Thames Tideway Tunnel
Thames Water Utilities Limited

Thames Water's Response to Local Impact Report from London Borough of Southwark

Doc Ref: **APP30.09**

Folder **150**
2 December 2013

Document Information
 Construction phase noise – summary of significant effects (day)
 Figure 1

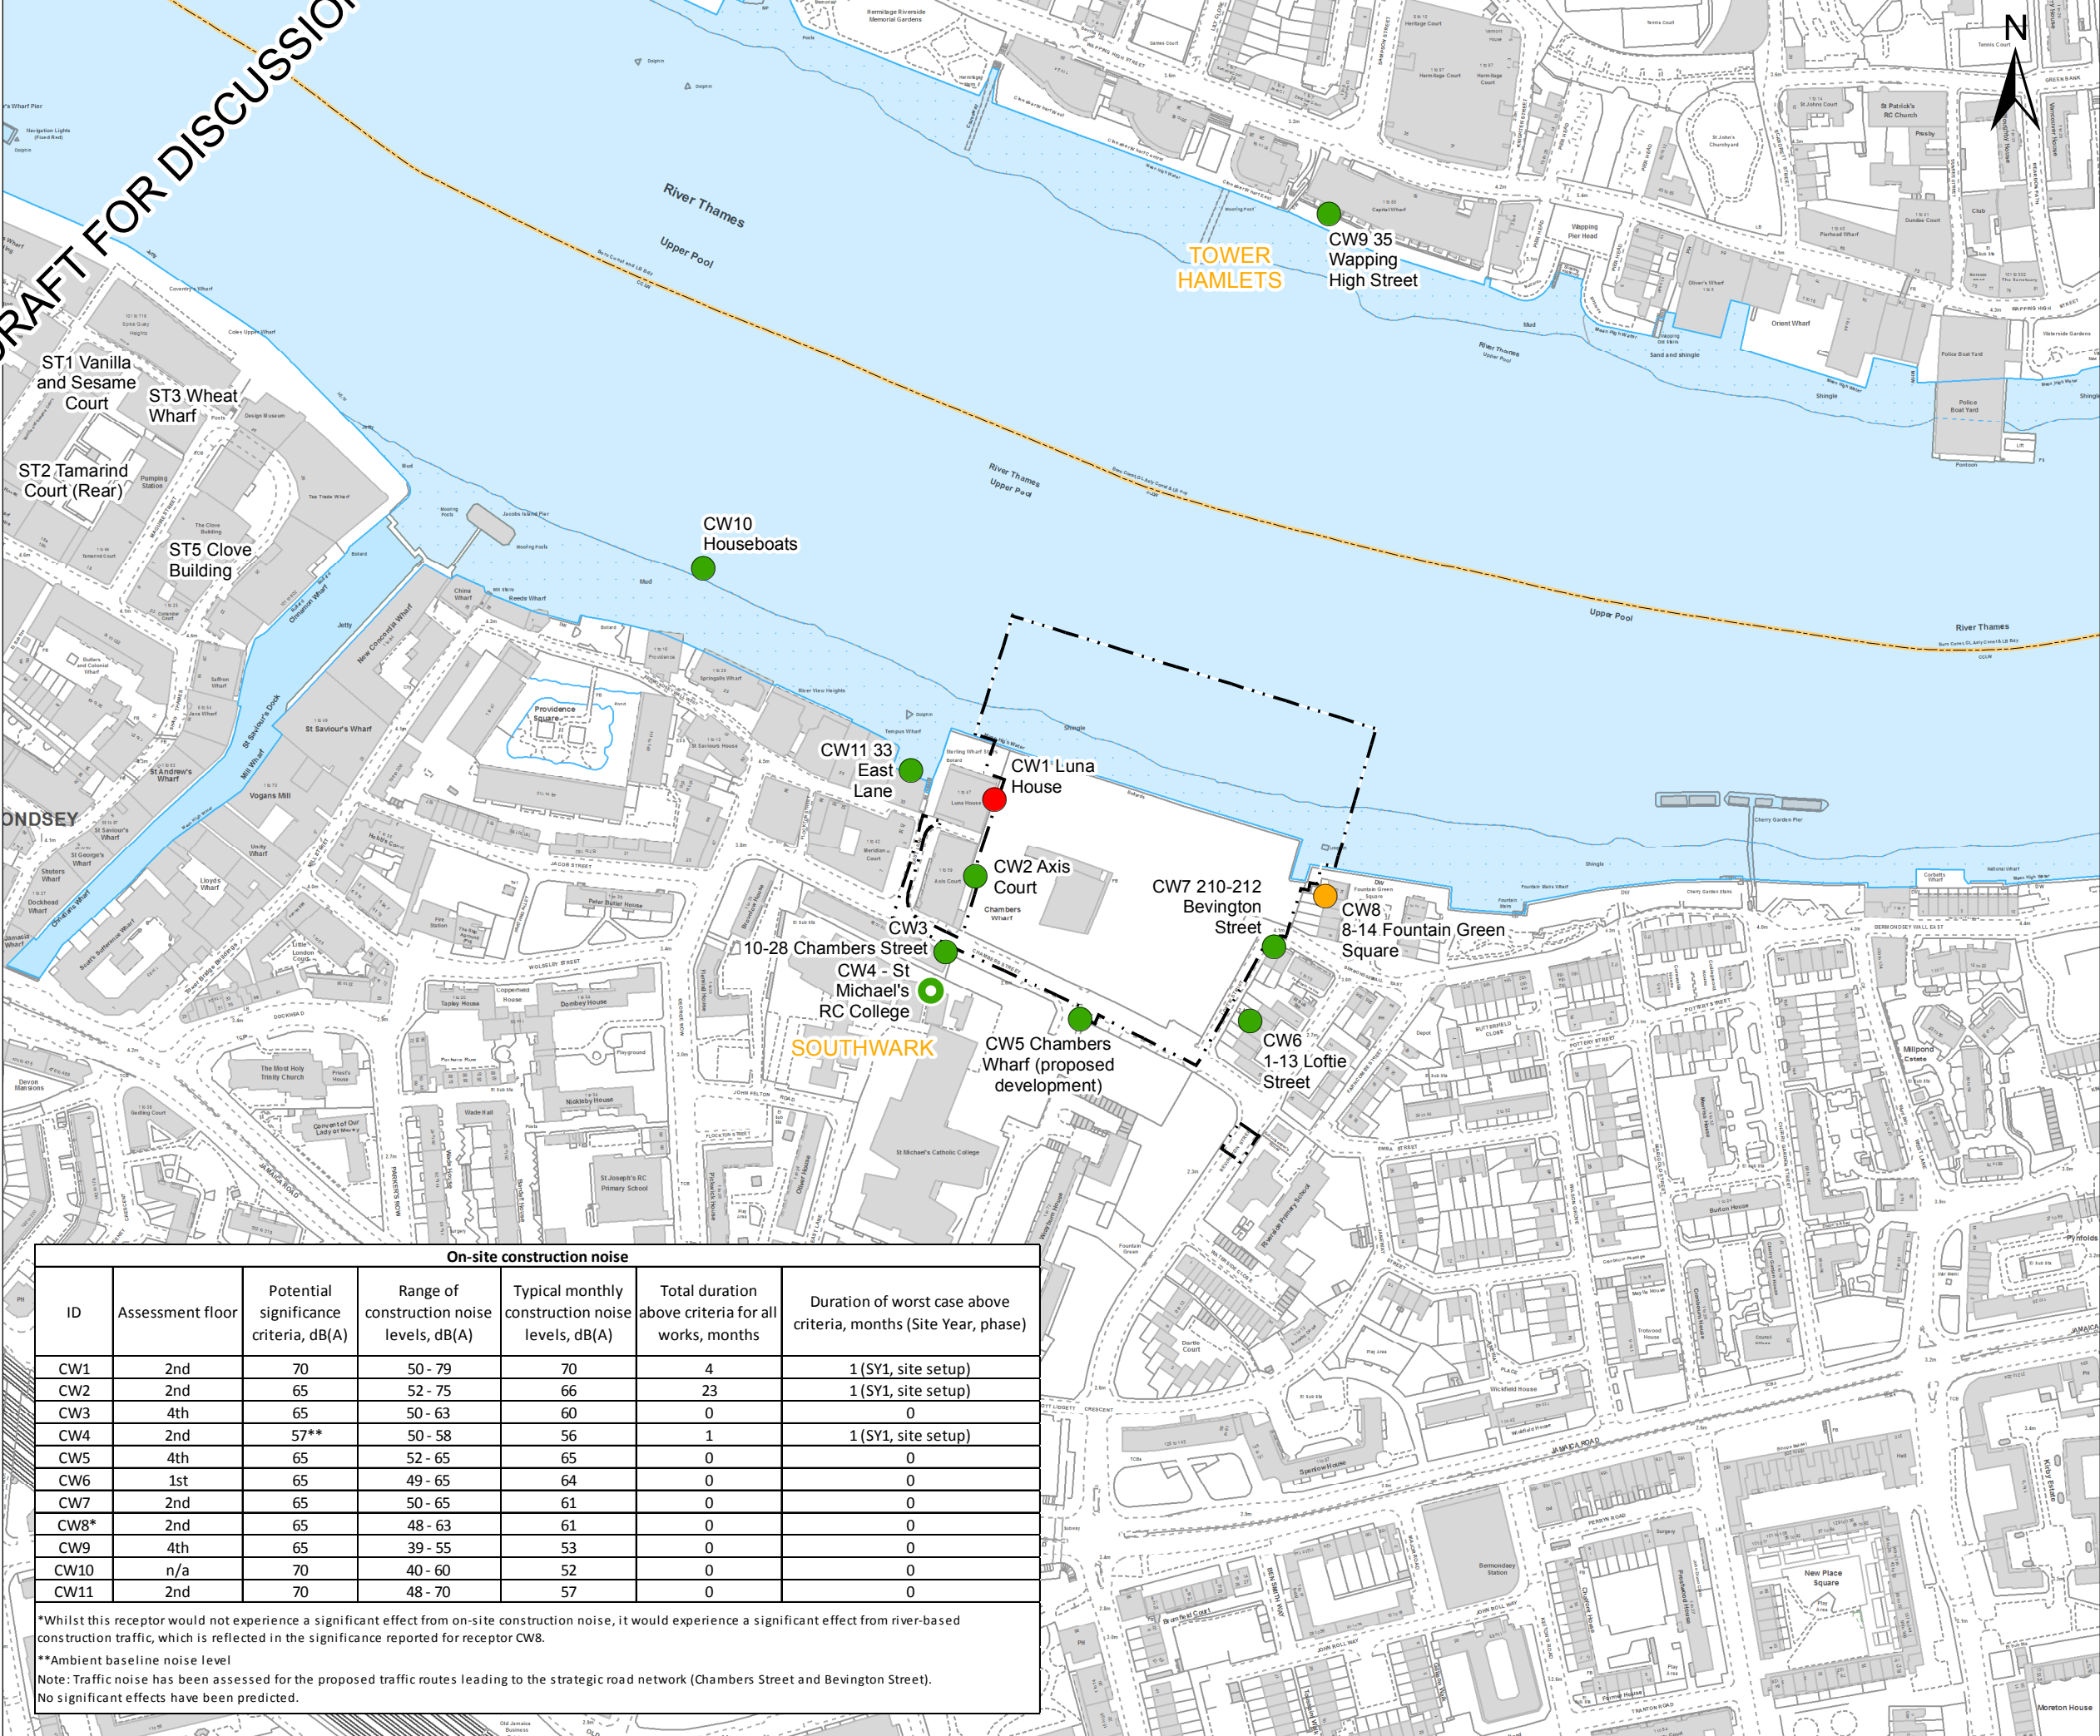
Ref	LIR para. ref	London Borough of Southwark comment	Our response
Noise and vibration			
8.	3.6 Summary	<i>“Noise levels in the Environmental Statement should be provided for all phases of the construction process”</i>	The daytime levels over the duration of the construction works and for all phases are presented for each assessed receptor in graphs in the relevant appendix (G.2) of the <i>Environmental Statement</i> (Doc ref: 6.2). Evening and night-time levels were not presented graphically because the activities during these periods are limited in number resulting in less variation in levels than you can see in the daytime graphs. Graphs for evening and night time noise would therefore show one or two flat lines for the activities in question. The purpose of the graphs was to illustrate the variation of noise levels over the construction period. Predicted evening and night time noise levels are however presented in Table 9.5.1 of each site volume.
